NORWICH TO TILBURY

EN020027

Comments on Submissions received at Deadline 7

Suffolk County Council [REDACTED]

Revision: A

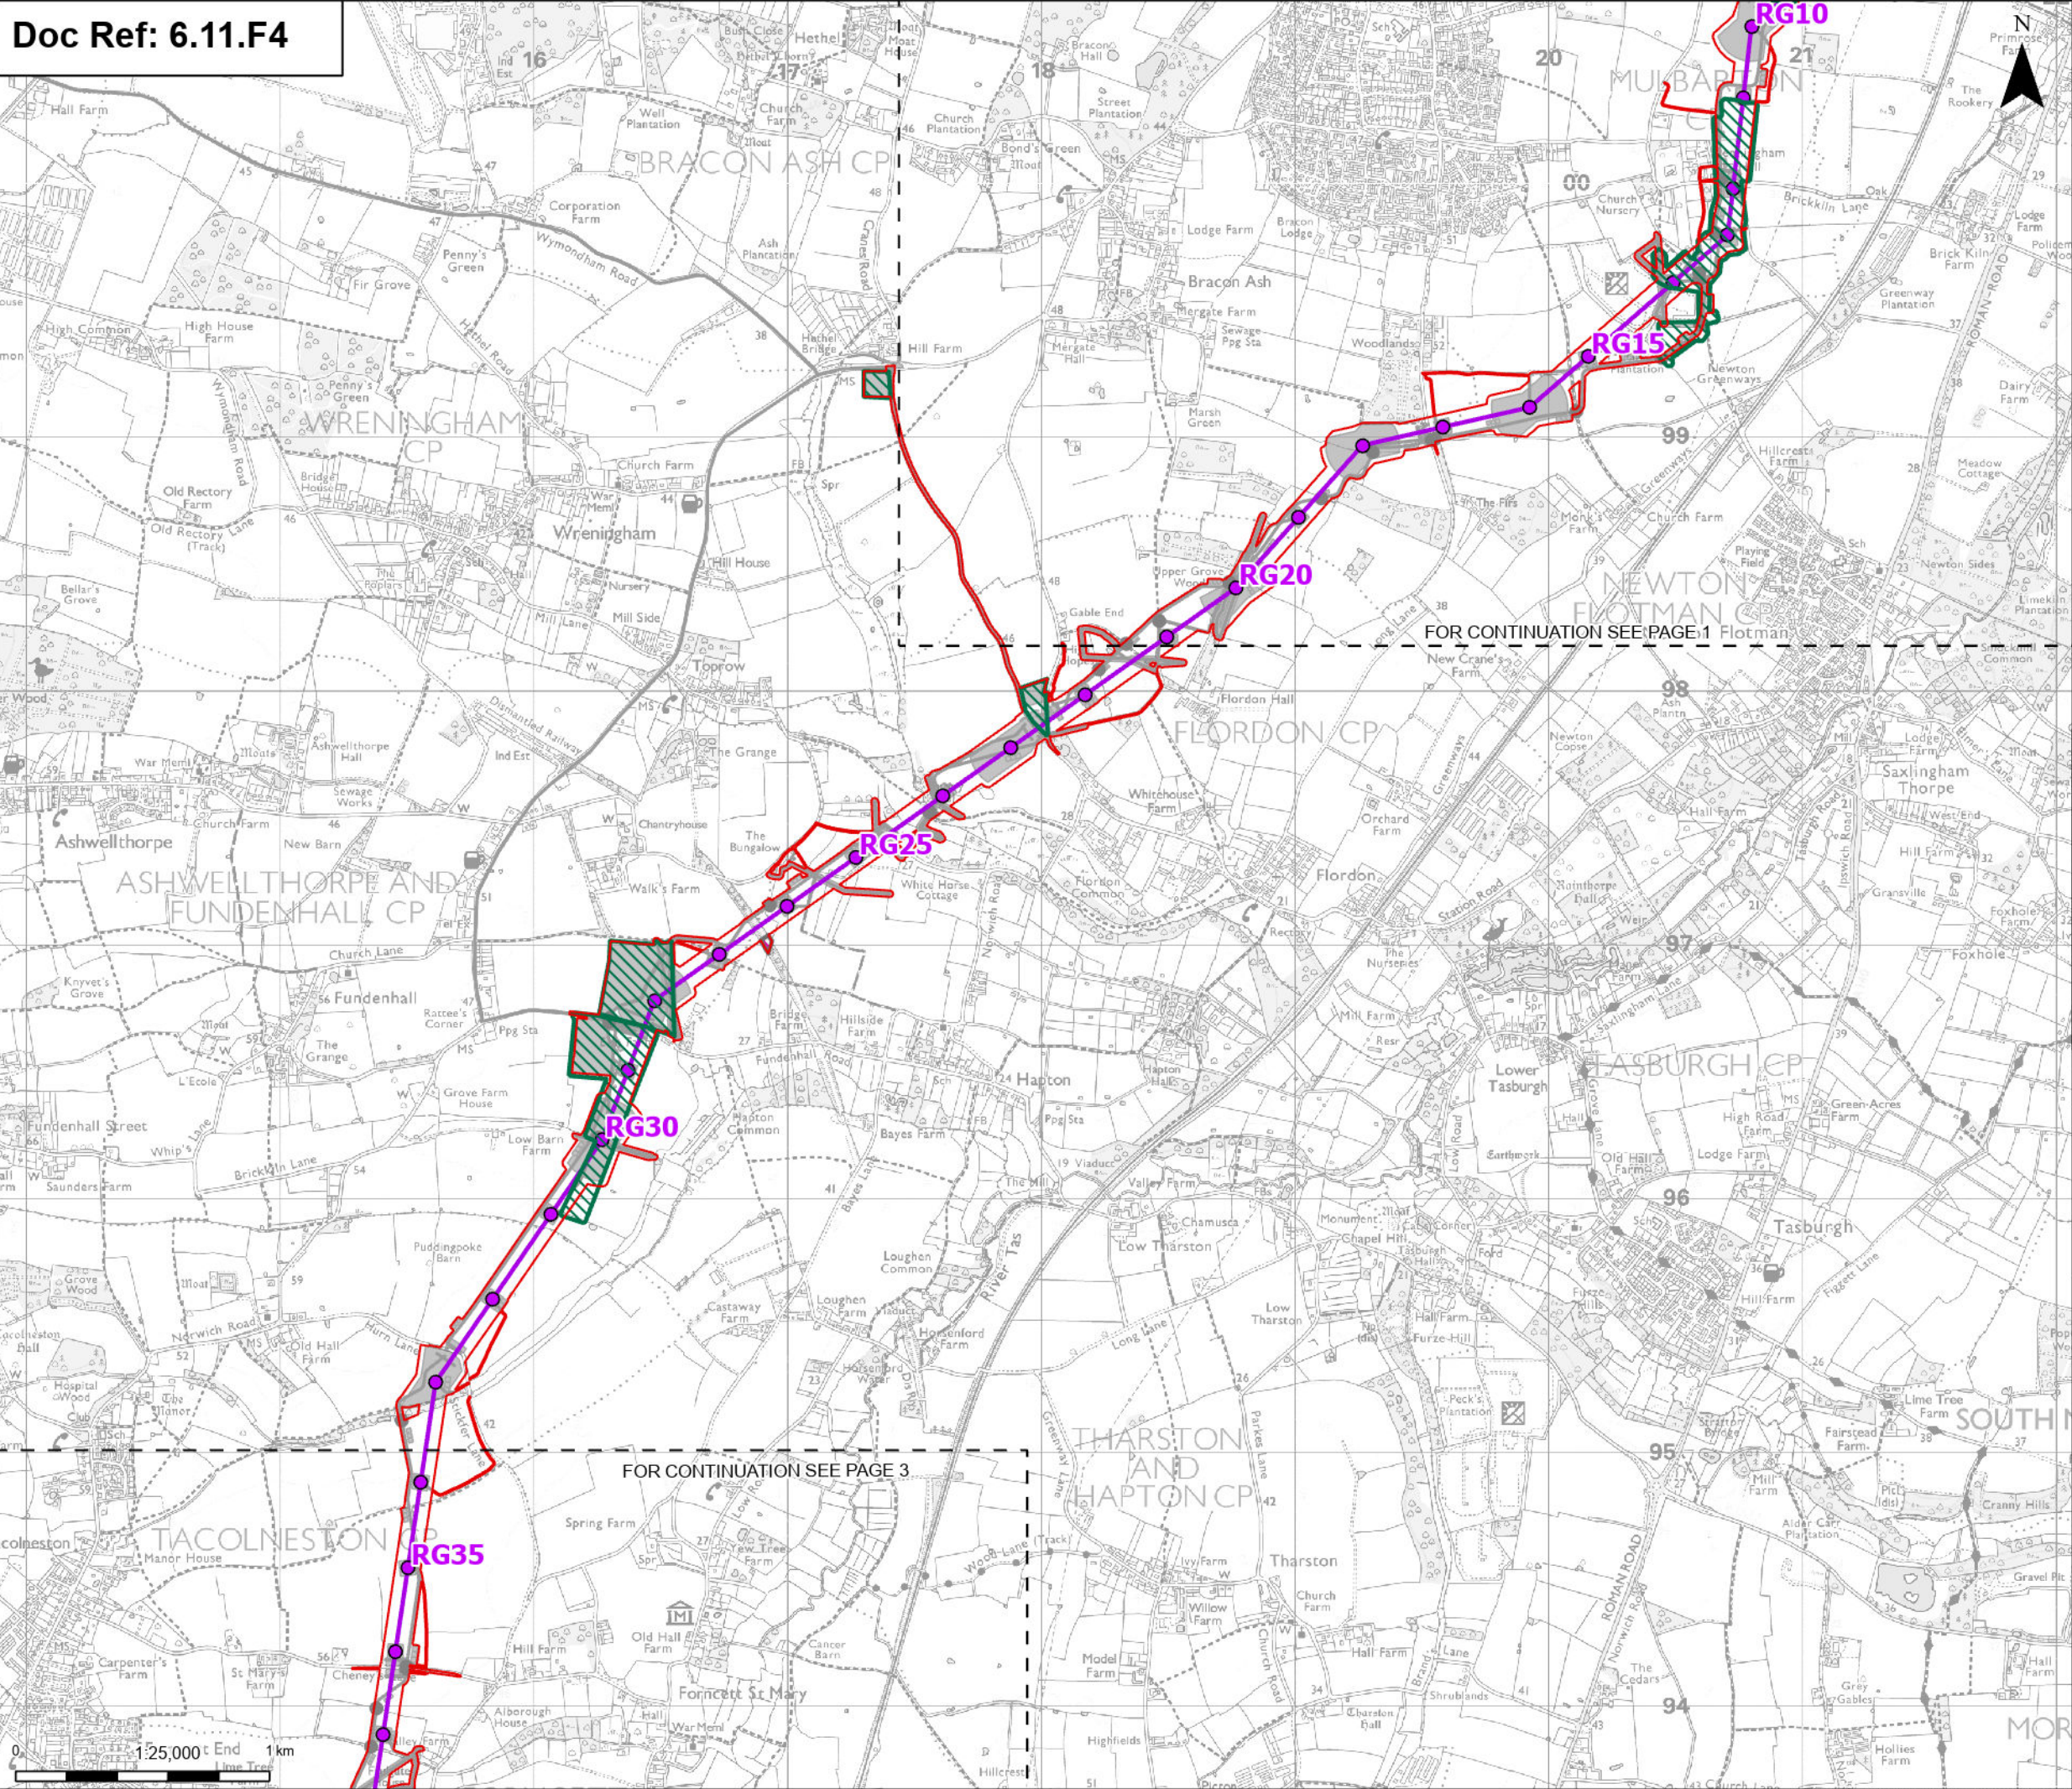
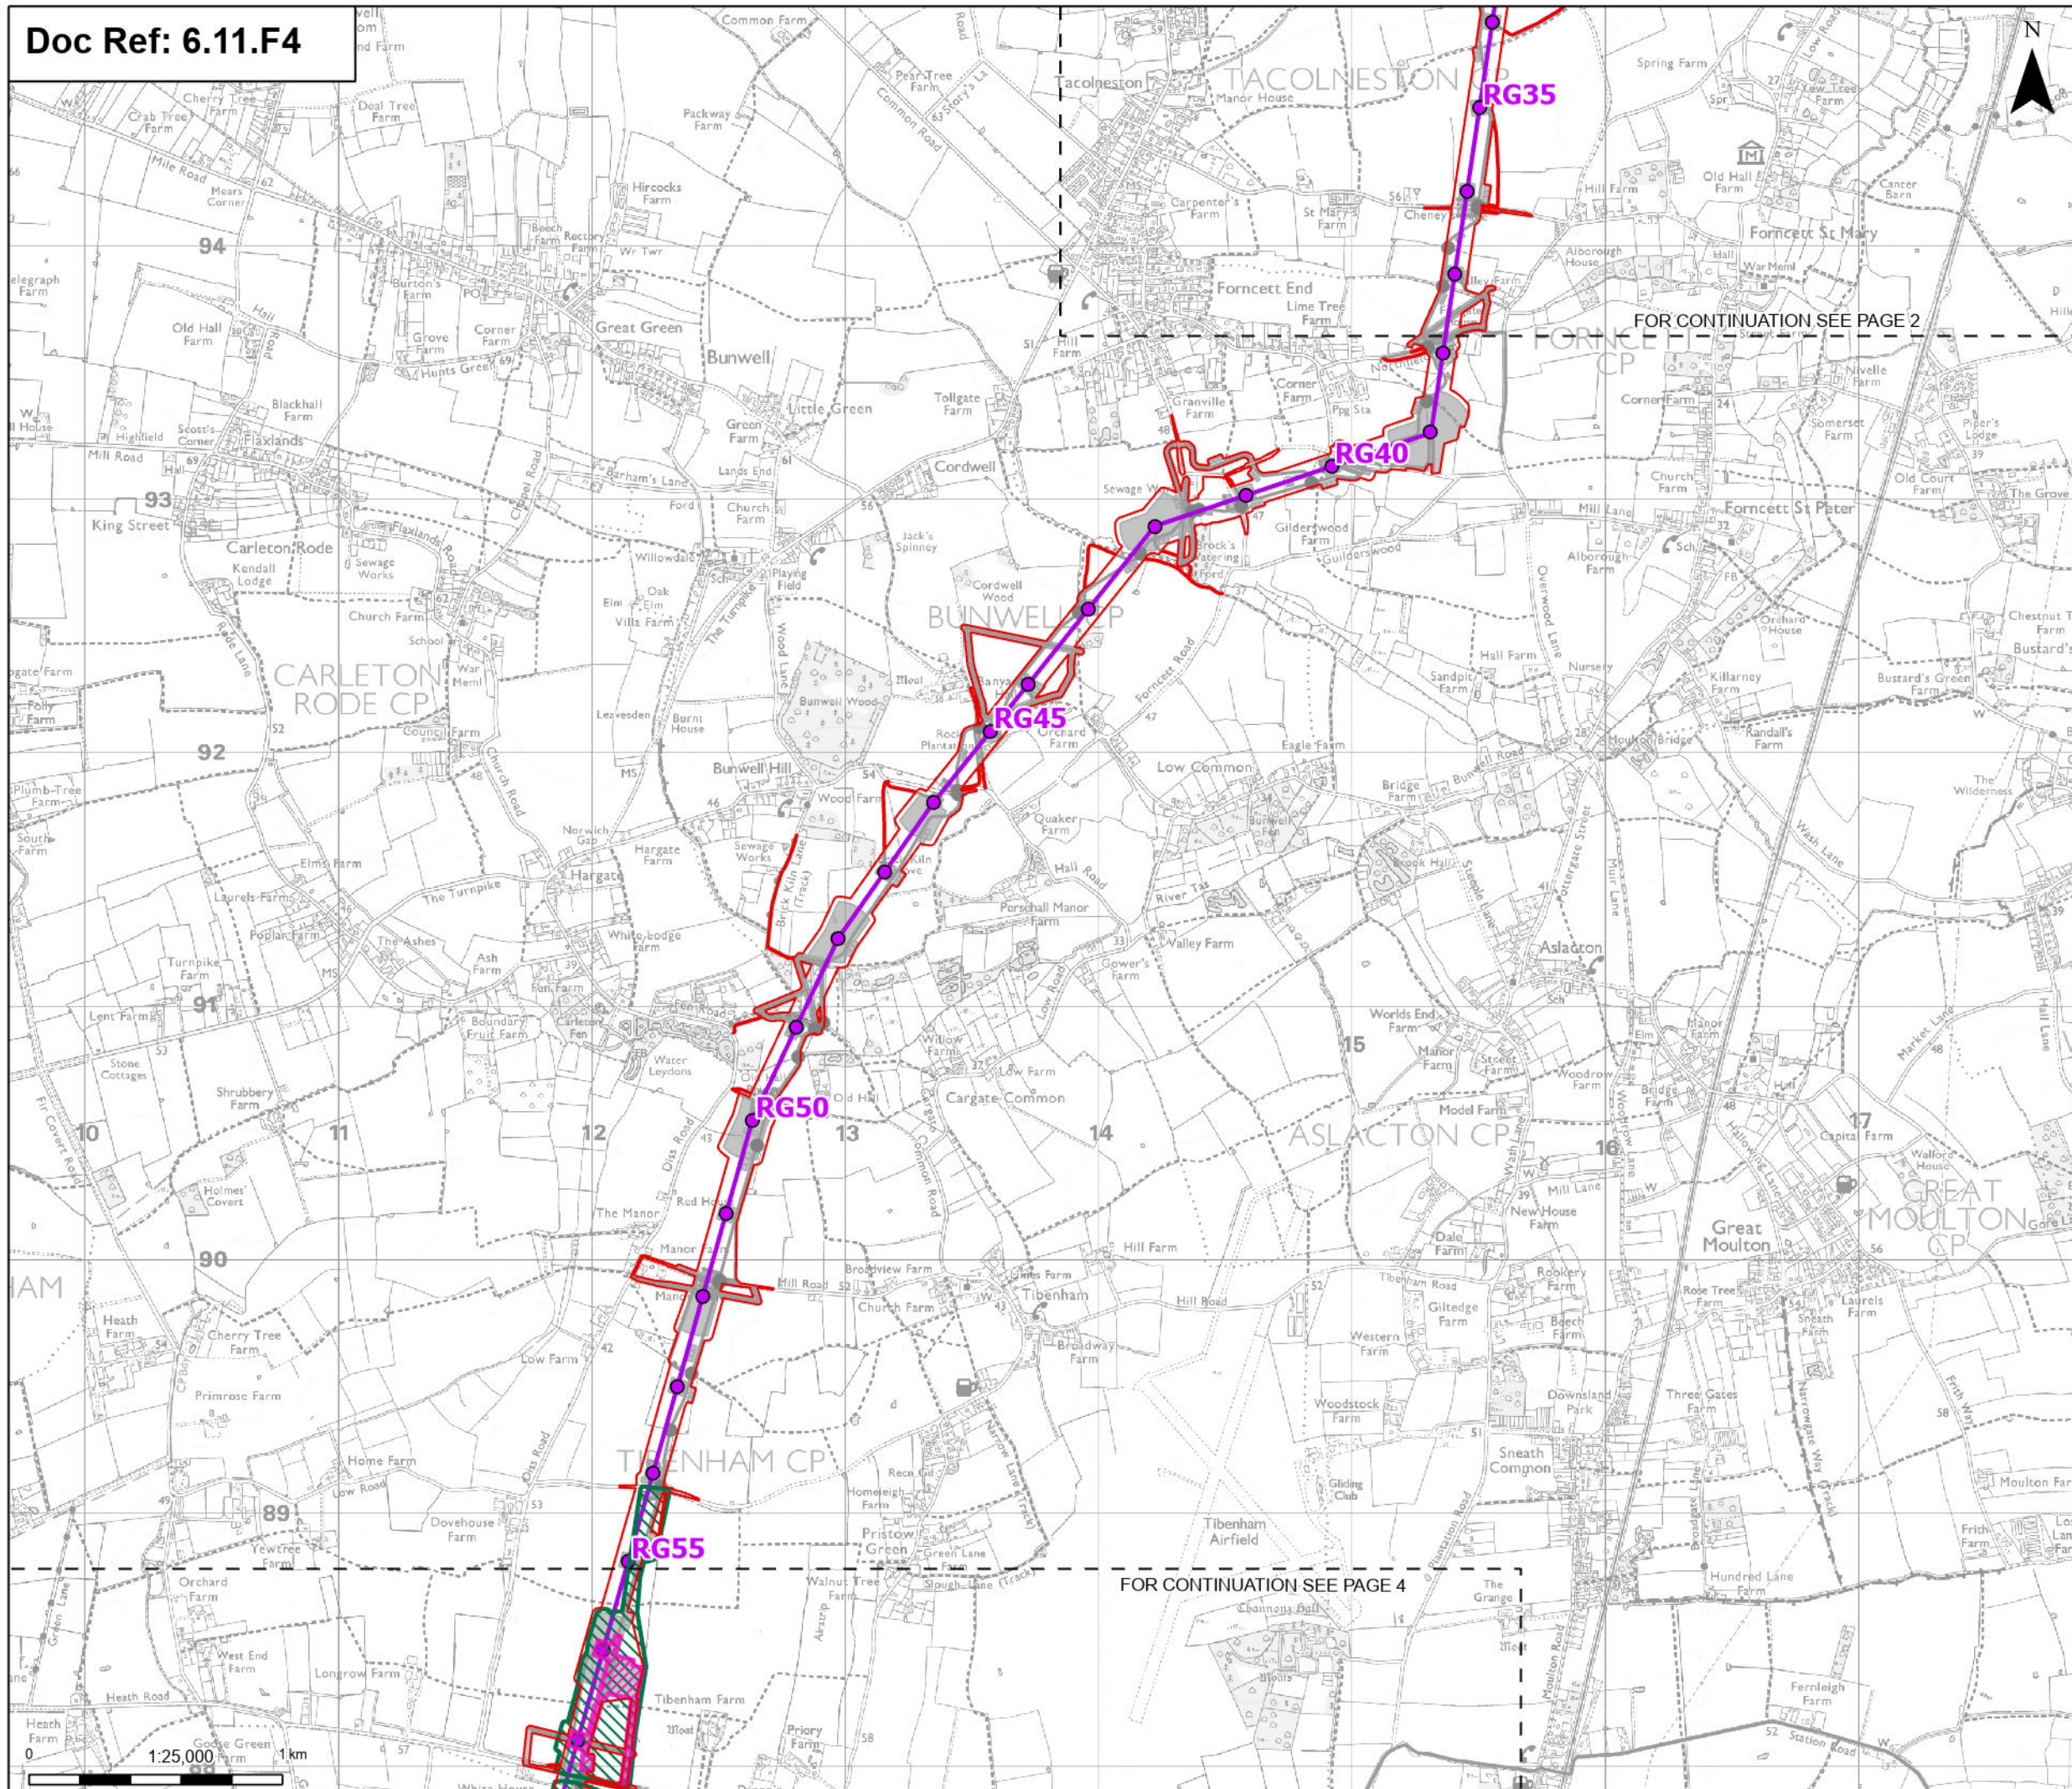
8.3	Archaeology	Figure 1 (Suffolk Sections B and C)	The title of the figure “<i>Progress of Priority geophysical survey, Priority archaeological trial trenching and Phase 2 geophysical survey and areas for Phase 2 archaeological trial trenching</i>” should be amended as follows: “<i>Progress of Priority geophysical survey, Priority archaeological trial trenching and Phase 2 geophysical survey and <u>indicative</u> areas for Phase 2 archaeological trial trenching</i>” SCCAS believe that all permanent accesses, SuDs ponds, 3rd party undergrounding of 132kV and 33kV should be depicted on the plan as requiring further archaeological assessment, evaluation and potential archaeological mitigation. Because these aspects of the scheme have the potential to seriously impact buried archaeological remains. Pulling areas should be highlighted as areas of potential construction impact to be informed by final design.
